## Memorandum

**Date:** 12.12.2019  
**Project:** The New Primary School at Warnervale  
**Document Reference:** SY171701-00-HME03-1  
**Client Reference:** NSW Department of Education  
C/- Billard Leece Partnership  
Level 6, 72-80 Cooper Street  
Surry Hills NSW 2010

### New Primary School at Warnervale – SSDA Response

NORTHROP
SKETCH DRAWING
Project: Warnervale PS
Title: Infrastructure Utility Services Impact - Preliminary Sketch
Date: 13/12/2019

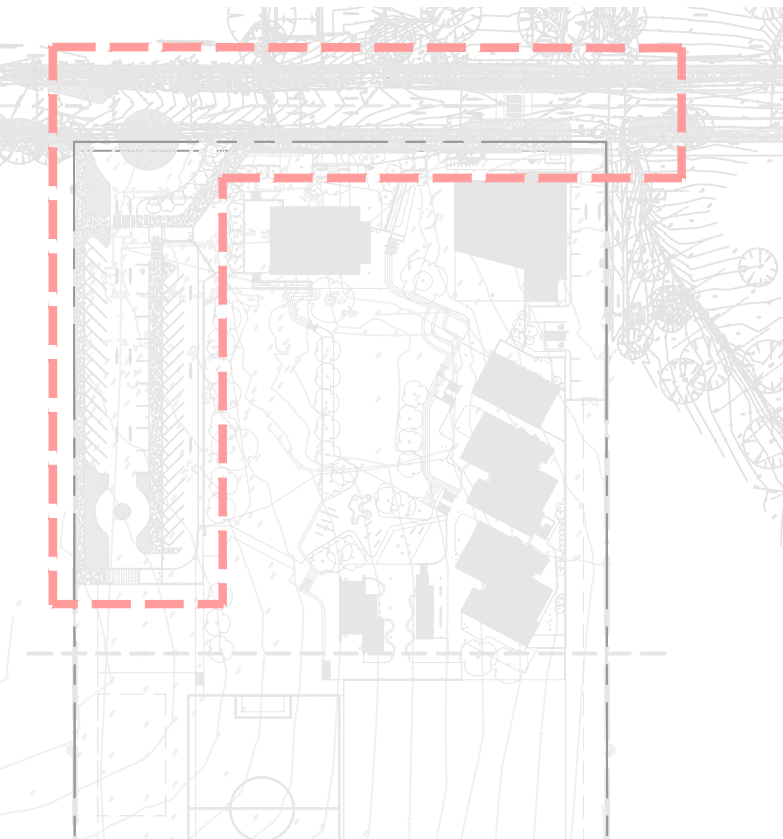
2. **Central Coast Council Comment: Water & Sewer**

*Water and Sewer issues will be dealt with through the Water Management Act process. Conditions to address this have been included.*

- While conditions have not been provided for our review, we understand that questions have been raised regarding the proposed road design in relation to the existing water, sewer and gas services. The impact of the proposed road works on the authority gas, water and sewer infrastructure services will be subject to further design development, however we have provided a preliminary Infrastructure Utility Services Impact sketch showing potential impacts for future consideration.
